Ref: 6/2022/0837/ADV
Date: 09/05/2022

HISTORIC BUILDINGS AND CONSERVATION ADVICE

RE: Cote Brasserie 1-3 Howardsgate Welwyn Garden City AL8 6AL

The application is for the installation of 2 sets of halo illuminated fascia text and 2 externally illuminated projection signs

Proposed Signs

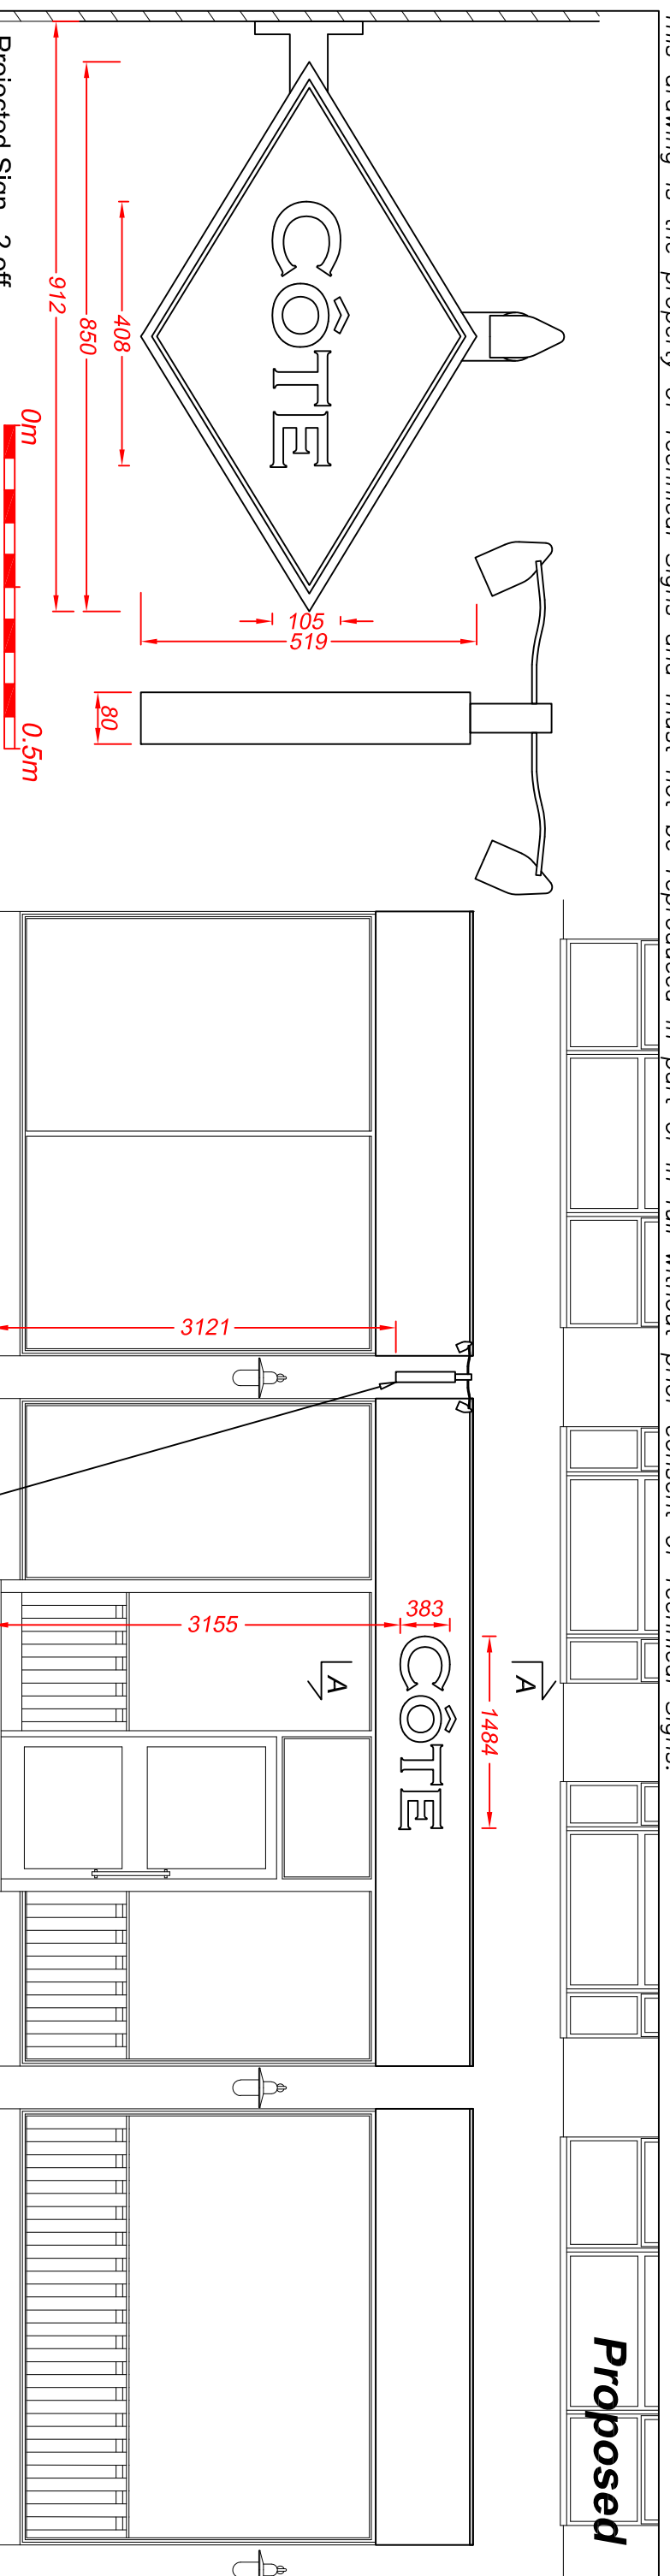
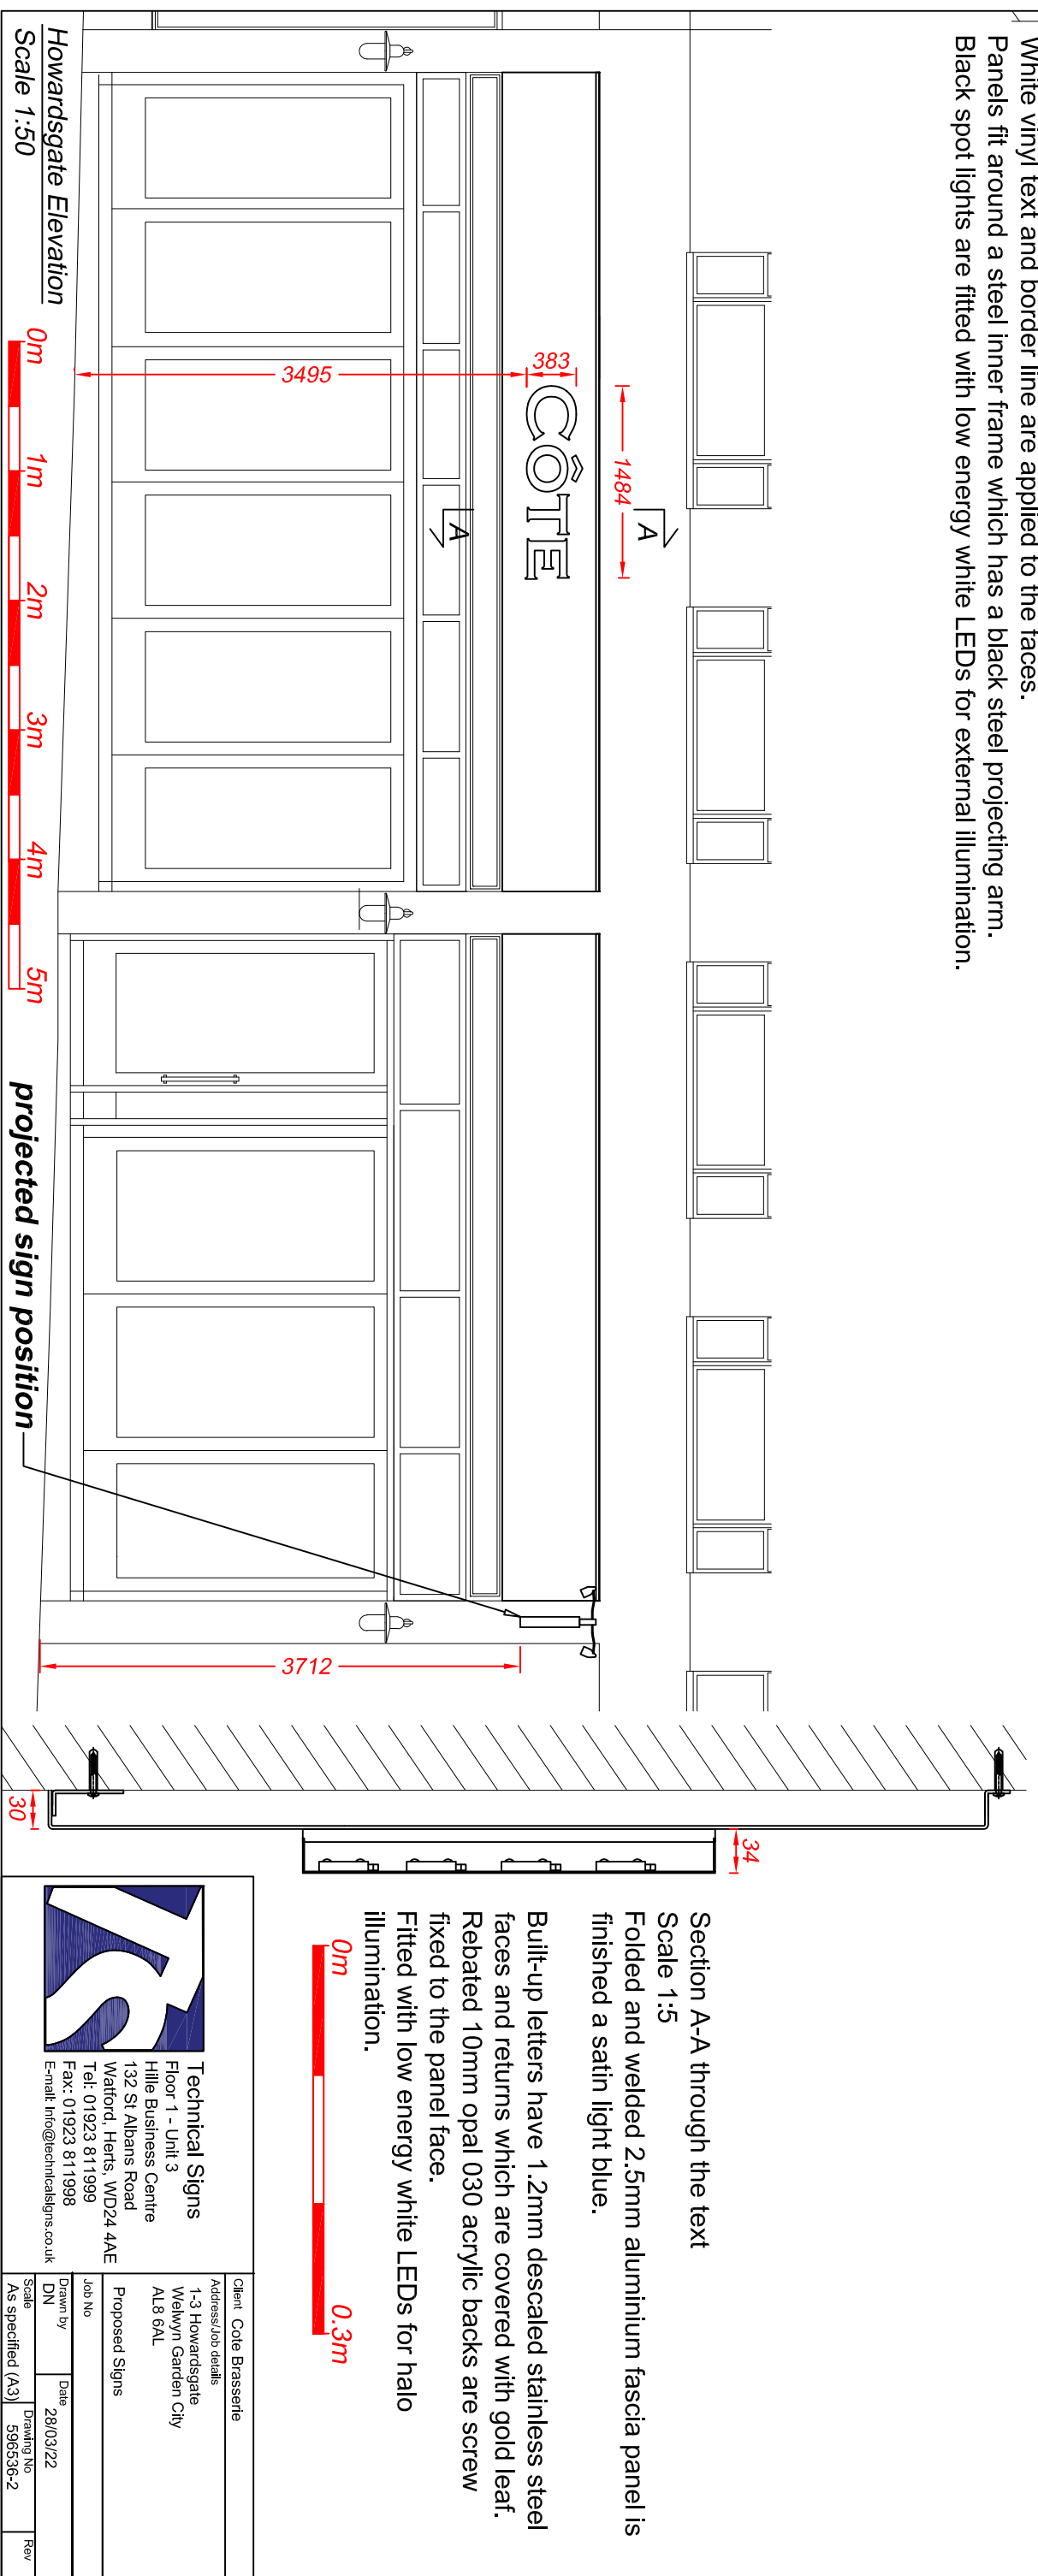
There are no objections to the proposed signage. However, it is recommended that the internal illumination of the main sign is omitted. It is stated within Welwyn Garden City Conservation Appraisal (September 2007) that internal illuminated signs and excessive lighting can detract from the conservation area. In this case the internally illuminated sign alongside the external illumination of the hanging signs would lead to excessive lighting and is considered to not be sympathetic to the building or the appearance of the Conservation Area.

If the above amendment is made, then the new signage would be in line with Section 72(1) of the Planning (Listed Buildings and Conservation Areas) Act 1990 and Chapter 16 the NPPF.
